26 November 2021

Our Reference: 21_82_CPPL_EDCP_DD

Subject: 1111-1141 ELIZABETH DRIVE SUBDIVISION, CECIL PARK (SSD 8859) ACCESS CONCEPT DESIGN

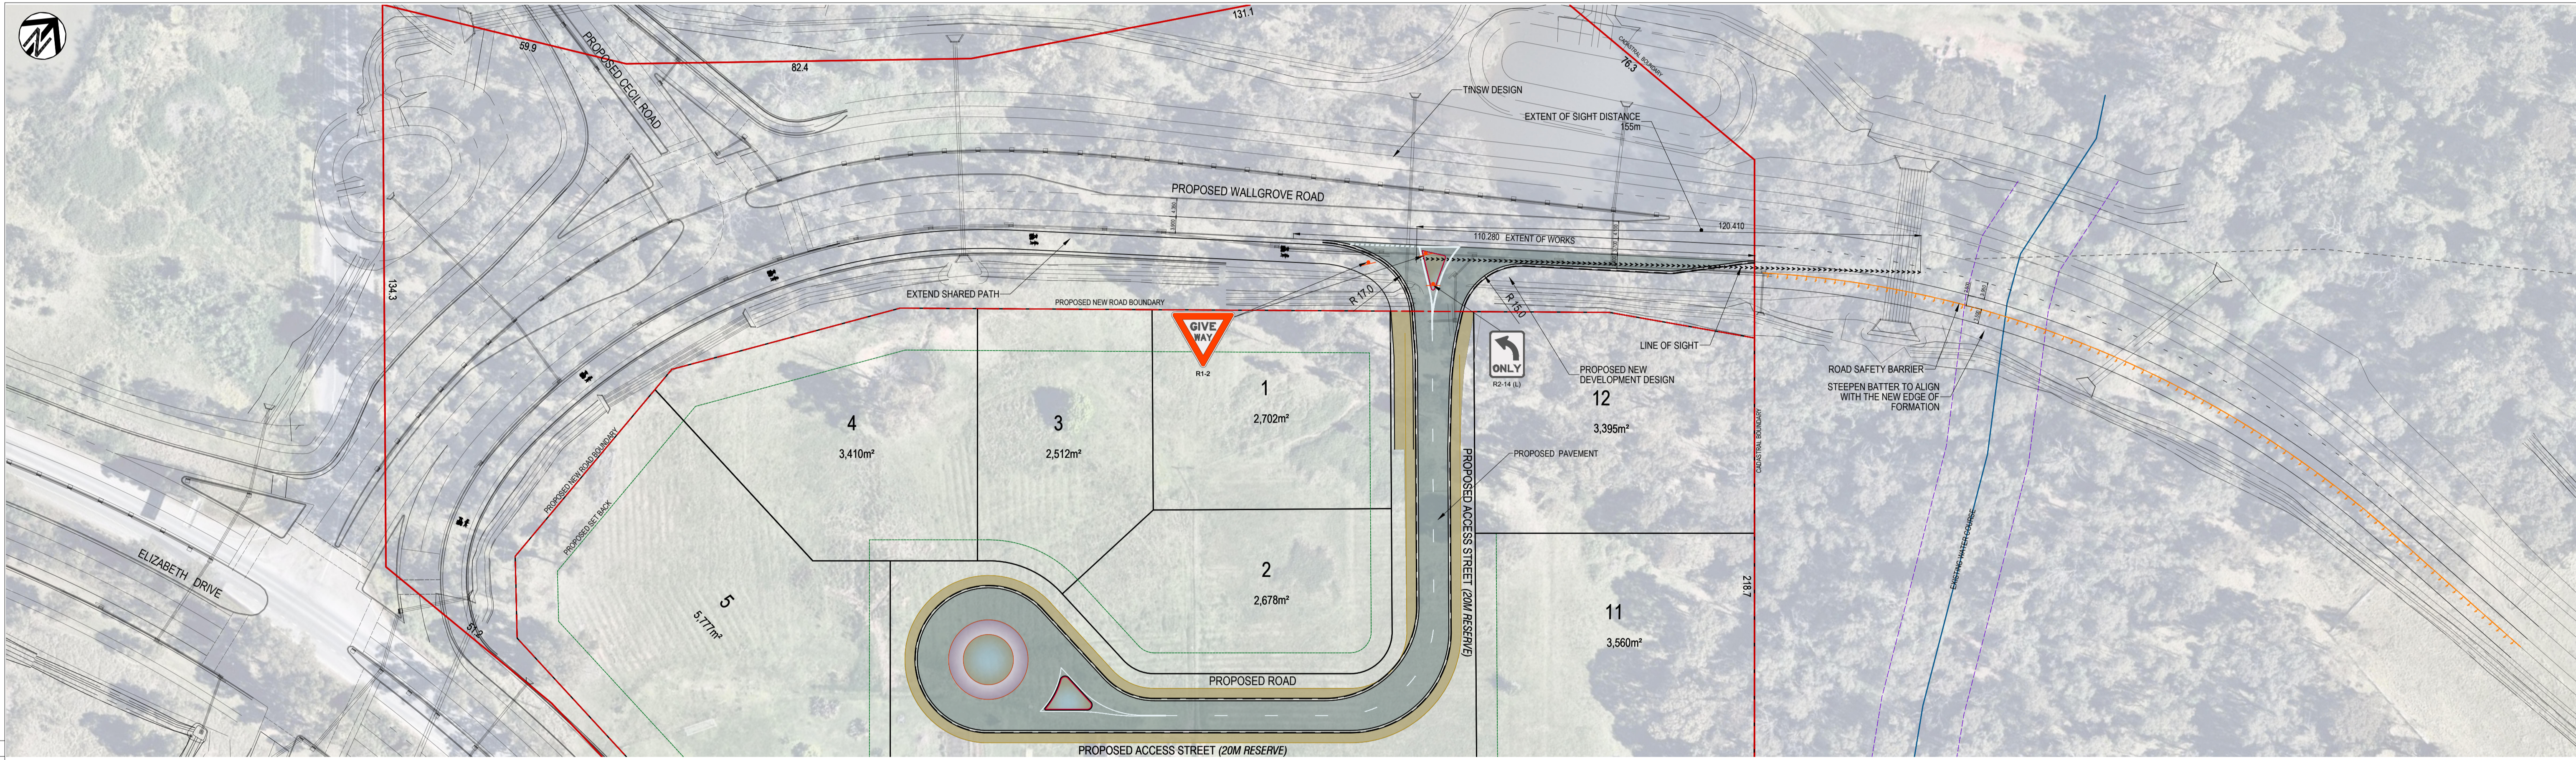
Review Comments	MU Group Response
TfNSW latest review comments (dated 22 November 2021) on the preliminary design submitted by MU Group to TfNSW. Refer to Appendix B.	
<p>a. It is requested that a deceleration lane should be provided at the frontage of the subject site for access arrangement. The deceleration should be located wholly within the property and dedicated as public road.</p>	<p>A deceleration lane contained wholly within the site has been provided in the latest design included in Appendix A.</p>
<p>b. The proposed left in/left out and deceleration lane including the length of the deceleration lane should be in compliance with AUSTROADS and for the design speed listed above.</p>	<p>The deceleration lane has a length of 61m, which complies with Austroads.</p> <p>Note that <i>Austroads, Part 4a, Section 5.2 Deceleration Lanes</i>, requires a deceleration lane length of 60m based on design speed of 70km/h and exit speed of 30km/h.</p>

<p>c. Plans including the swept path analysis should be modified to reflect the above requirement.</p>	<p>Swept Paths analysis for 26m B-Doubles and 35m B-Triples are included in Appendix A</p>
<p>d. TfNSW queried on 25 November 2021 over the phone on the presence of OSD for the site.</p>	<p>The development site has an Onsite Detention in accordance with Fairfield City Council requirements.</p>
TfNSW correspondence (dated 12 November 2020). Refer to Appendix C.	
<p>a. The proposed access to the site on the new realigned Wallgrove Road is located around a bend and TfNSW raises safety concerns with the sight distance at the proposed access road. A sight distance assessment should be provided to demonstrate the required sight distance is achieved.</p>	<p>Sight distance check has been undertaken included in Appendix A.</p> <p>The sight distance check confirms that the required sight distance of 151m (<i>Table 3.2 of Austroads Guide to Road Design Part 4A</i>) for a design speed of 70m/h is achieved.</p>

<p>b. The traffic report p.11 shows a proposed left turn slip lane from the realigned Wallgrove Road onto the access road (access to the subject site), which also continues after the access road to form two lanes on the realigned Wallgrove Road continuing to the intersection with Elizabeth Drive. This will potentially cause significant safety and operational issues as traffic turning in and out onto and from the access road would assume these vehicles on the kerb side lane are turning left onto the access road, however, these vehicles may choose to continue to travel straight on Wallgrove Road. Further, visibility and sightlines for traffic exiting from the access road would also be restricted by traffic travelling along the kerb side lane before the proposed access road.</p>	<p>The updated design provides a deceleration lane separate from the through lanes on Wallgrove Road. A sight distance check confirms that the updated design achieves the required sight distance for the design speed.</p>

<p>c. The proposed access to the site is uncontrolled and the potential for conflict is high due to it being at a point where drivers are merging and diverging.</p>	<p>A priority control (Give Way) is provided for exiting vehicles. Signage and line marking measures would be developed as part of the detailed design to reduce any residual risk.</p>

<p>d. TfNSW require the proposed access to the site on the realigned Wallgrove Road to be located to the farthest point of northern boundary of the site, away from the proposed intersection at Cecil Road.</p>	<p>The proposed access to the site has been located to the farthest point on the northern boundary of the site to satisfy the design parameters. Relocating the access further to the north is constrained by property boundary and Austroads requirement to the deceleration lane length.</p>
<p>e. A road safety audit is also required for the proposed access arrangement to the site given the above concerns.</p>	<p>A Road Safety Audit has been undertaken and attached as Appendix D. Responses to the RSA findings are described below.</p>
<p>f. A swept path analysis for the largest vehicle accessing the site should be provided.</p>	<p>Swept Paths analysis for 26m B-Doubles and 35m B-Triples are included in Appendix A.</p>

<p>g. Please provide more information on proposed footpaths / pedestrian access to the site along Elizabeth Drive and new Wallgrove Road. Pedestrian fencing will need to be provided to ensure pedestrians would be crossing at the designated crossing facilities.</p>	<p>Updated design in Appendix A includes additional information on proposed paths including proposed pedestrian fencing. This item can be detailed further in the detailed design stage.</p>

<p>a. Safe intersection sight distance for left turning vehicles out of the access road is not achieved to southbound vehicles in Wallgrove Road. Drivers may become impatient and pull out into the southbound travel lane on Wallgrove Road with insufficient gaps in the traffic causing rear-end and intersection type crashes. This issue could be exacerbated by the vertical alignment on Wallgrove Road (not assessed under this safety audit) as well as the presence of vehicles turning left into the development. It is noted that other options have proposed an intersection further north on Wallgrove Road. This does not improve the safety risk described above due to the presence of the horizontal curve in Wallgrove Road and the terminating leg of the T-intersection being on the inside of the curve</p>	<p>Sight distance check has been undertaken included in Appendix A.</p> <p>The sight distance check confirms that the required sight distance of 151m (<i>Table 3.2 of Austroads Guide to Road Design Part 4A</i>) for a design speed of 70m/h is achieved.</p>

<p>b. The width and kerb return radii at the access road exit appears to be excessive. This will result in vehicles stopping at the give way line at an undesirable angle to oncoming traffic, increasing the likelihood of crashes highlighted in Risk 1. Drivers may also attempt to turn two abreast given the significant width at the intersection or illegally make a right turn out of the proposed access road resulting in right-through and rear-end crashes.</p>	<p>This has been addressed in the latest design whereby the angle of the edge line adjacent to the median splitter island has been amended and chevron line marking provided. The design complies with the High Angle Entry left turn requirements in accordance with <i>Austroads Part 4a, Figure 8.7</i>. This has improved the angle to oncoming traffic thus reducing this risk.</p>
<p>c. Turning left out of the development access road and right into Cecil Road requires attaining a suitable gap in the southbound traffic on Wallgrove Road and then changing across one lane to enter the right turn bay. The distance available to carry out this sequence of manoeuvres is insufficient, and drivers may have to force their way through. This disruption to the traffic flow may be worsened if the right turn bay has several vehicles already waiting in it. Rear-end and lane change crashes could occur as a result of this geometry.</p>	<p>Signage and line marking measures would be developed as part of the detailed design to reduce any residual risk. This would be integrated with TfNSW Wallgrove Road design.</p>
